**Your Ref: 2026/0232
Our Ref: B/01185**

**Land to the south of Bloomhouse Lane, East of Woolley Colliery Road, Darton, Barnsley –
(BARN) Erection of 119 dwellings, open space and associated infrastructure**

1.) The landscaping details submitted on drawing 'Site Layout' 25-5808-01 (revision B) dated 19/03/26 that has been prepared by JRP is not acceptable. The following point(s) should be addressed:

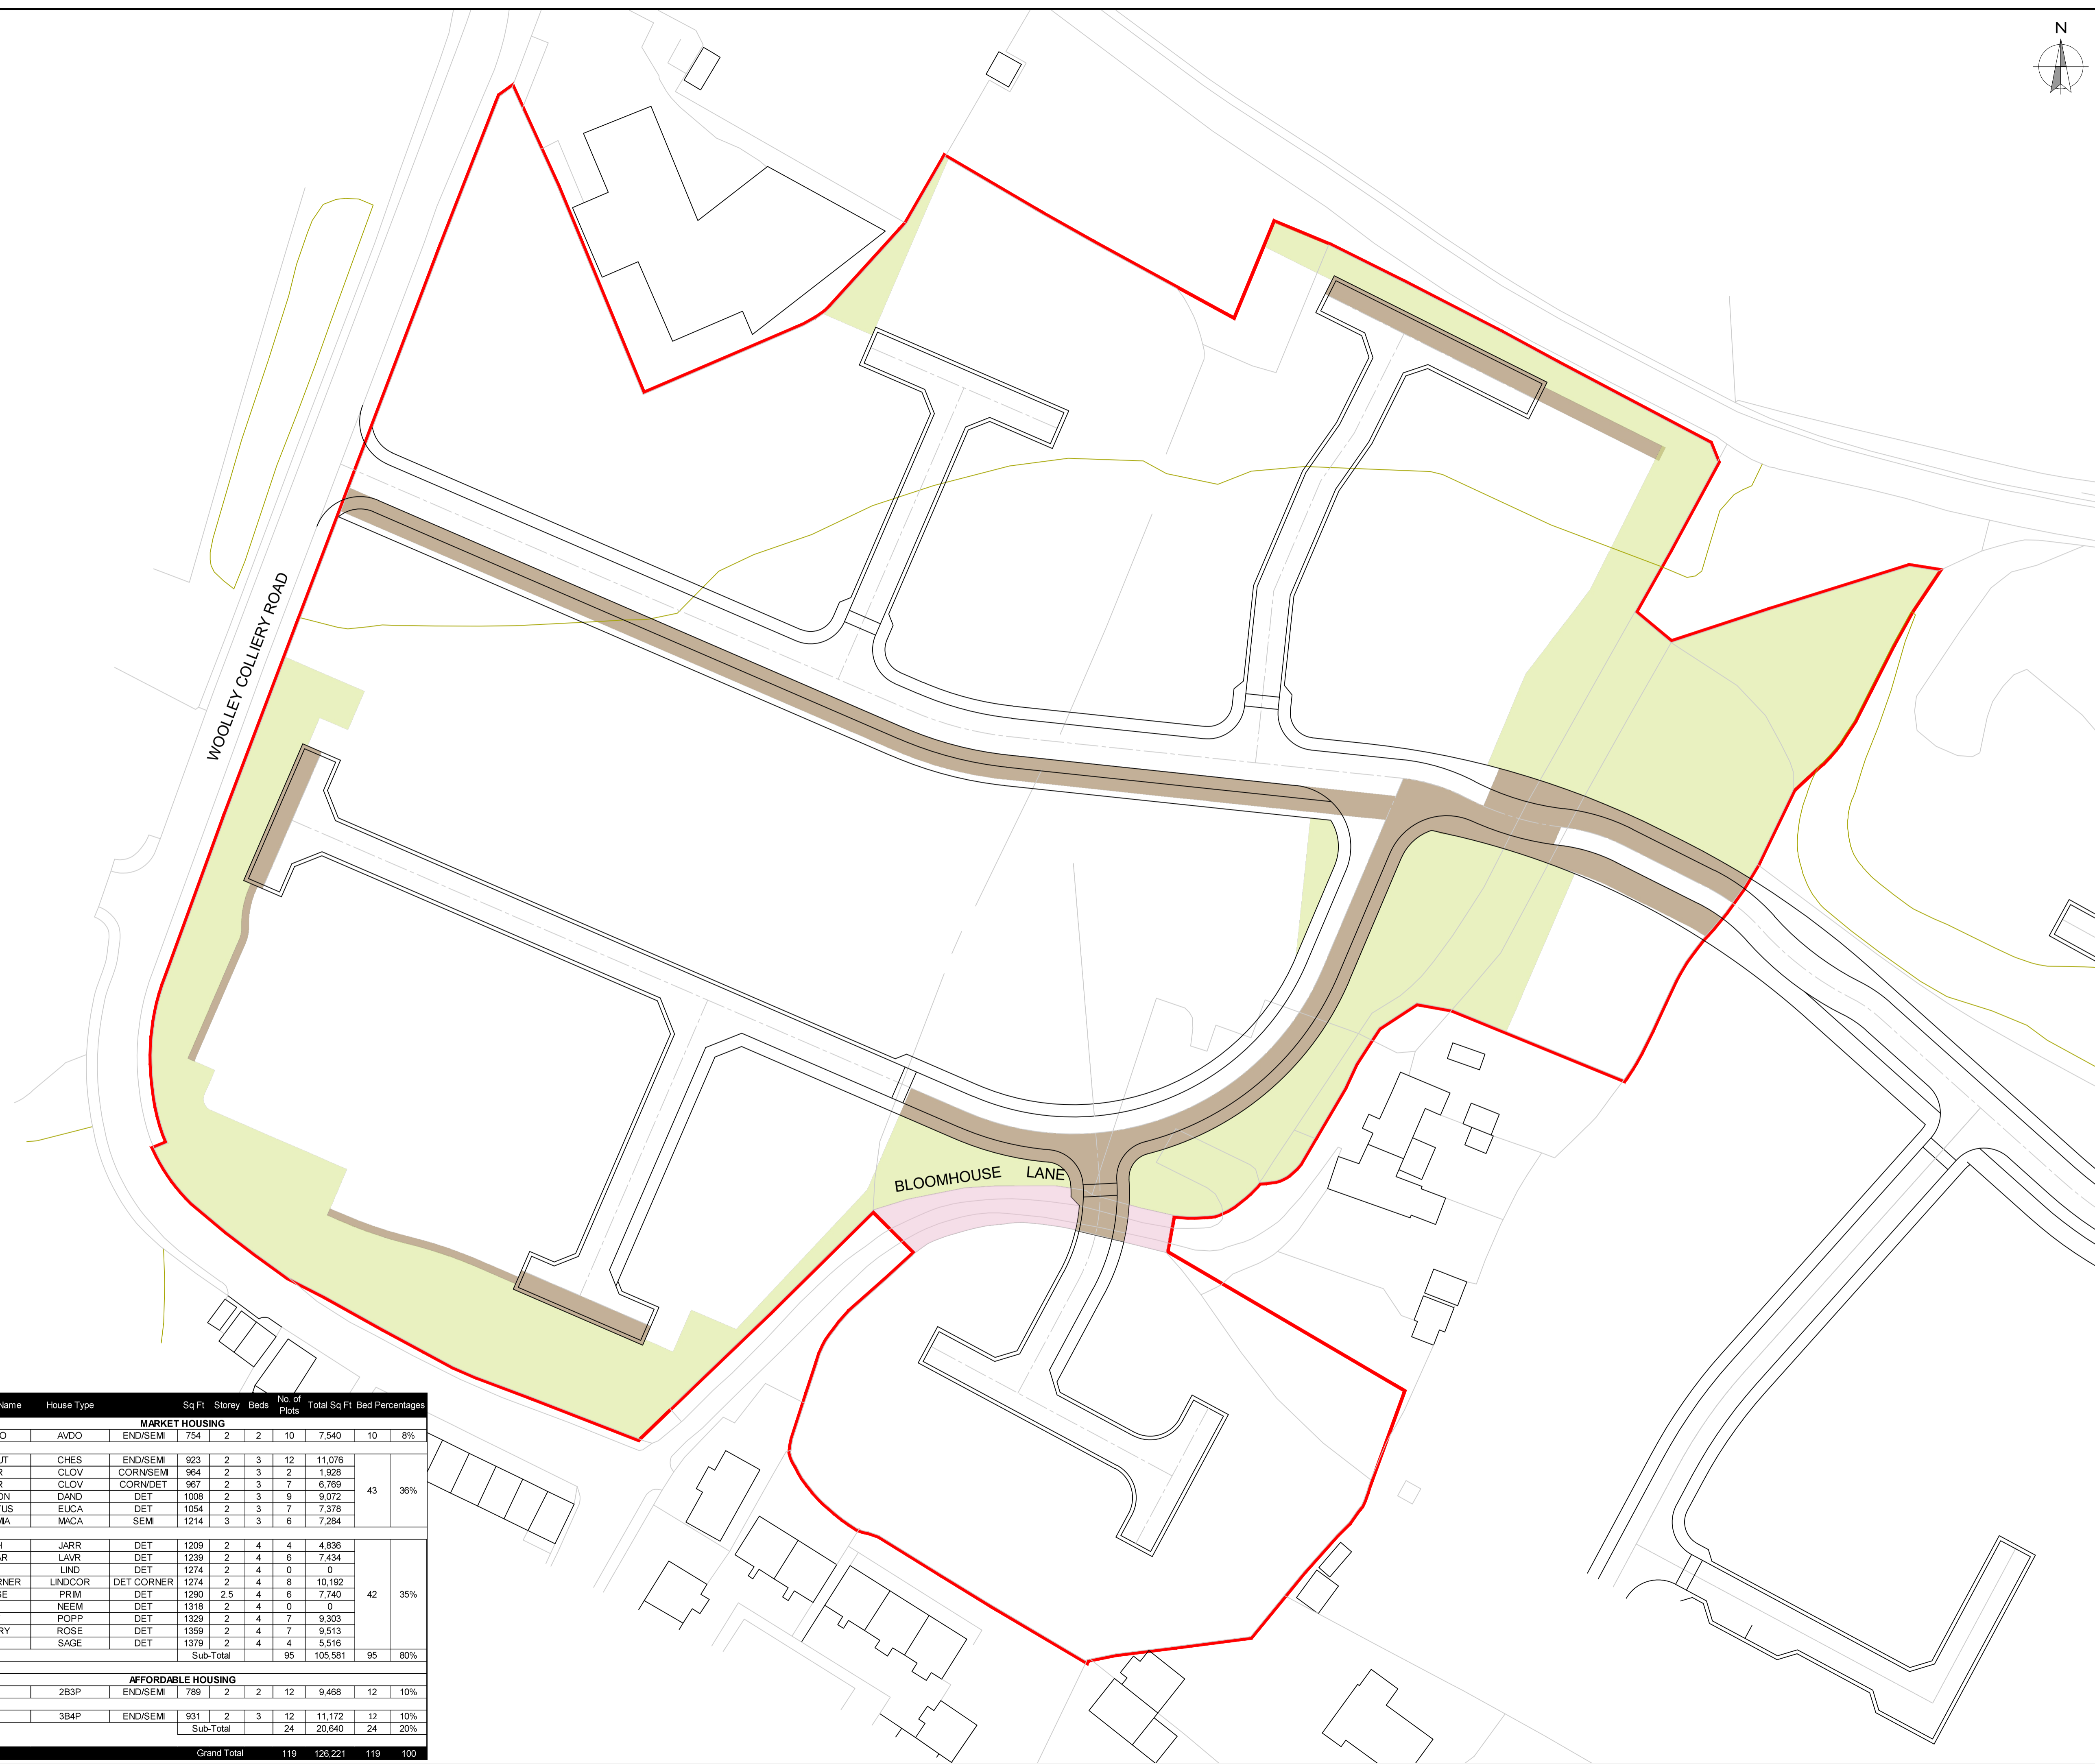
NOTE- it appears from the submitted site layout that new tree planting will be sited over the public sewerage system located within the site. This could seriously jeopardise Yorkshire Water's ability to maintain the public sewerage network and is not acceptable. We therefore OBJECT to the development layout as currently shown. I strongly advise that, prior to determination of this application, the site layout is amended to allow for adequate protection of the sewers. For further information, the developer should contact our Developer Services Team: telephone 0345 120 84 82 (option 1) or email technical.sewerage@yorkshirewater.co.uk.

- a.) the submitted drawing appears to show new tree planting within 5 metres of public sewer network
- b.) the submitted drawing should show the site-surveyed position of the public sewer crossing the site
- c.) the submitted drawing should show the required tree planting stand off -- or an agreed alternative scheme

There should be no new tree planting within 5 metres of the public sewer network.
